Overhead Door Company
Reed Door Company
Holland ME

Revision Hand Rail Detail 2/9/17

533 Riverside Ind Pkwy
Portland ME 04103

Building Permit #
2016-02842

TOP view

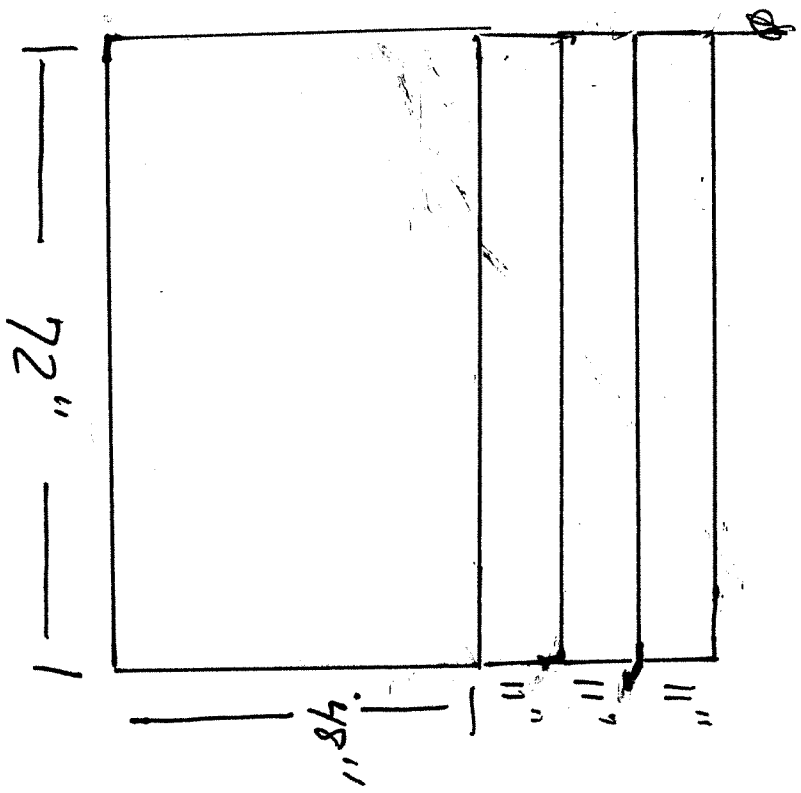
* Revision 4/11/17 Stair width & landing area Depth

Change - concrete forms need to be set so that
Landing Depth is 54" and stairs width will be
88"
